352 Rocking horse Ln

PROJECT TYPE	PROPOSED SHED
DECK AREA	196 SQF
CLIENT	
ADDRESS	352 Rocking horse Ln

FLOOR PLAN
SCALE: 1/4"=1'0"

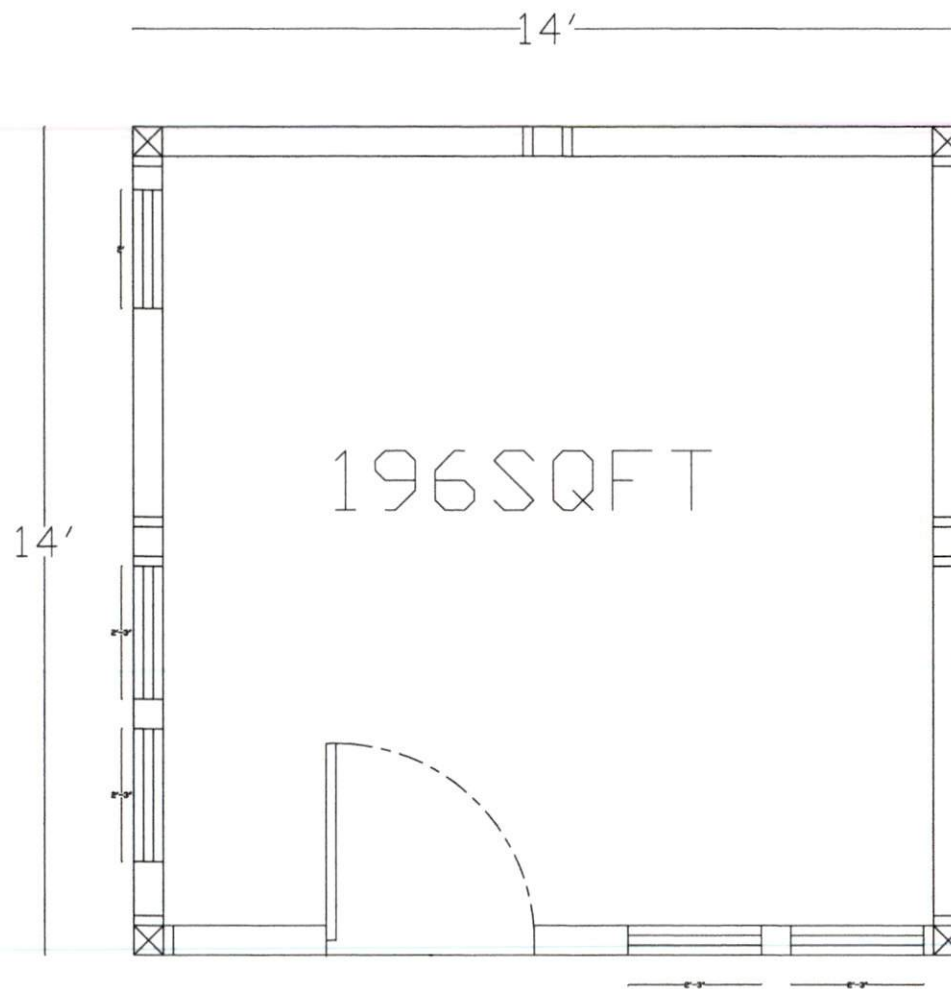
Ceiling joists shall be 2x6 @16oc with no storage above.
Rafters shall be min 2x4 @ 16 oc w/ 2x6 ridge minimum. There are no roof framing details in this plan.
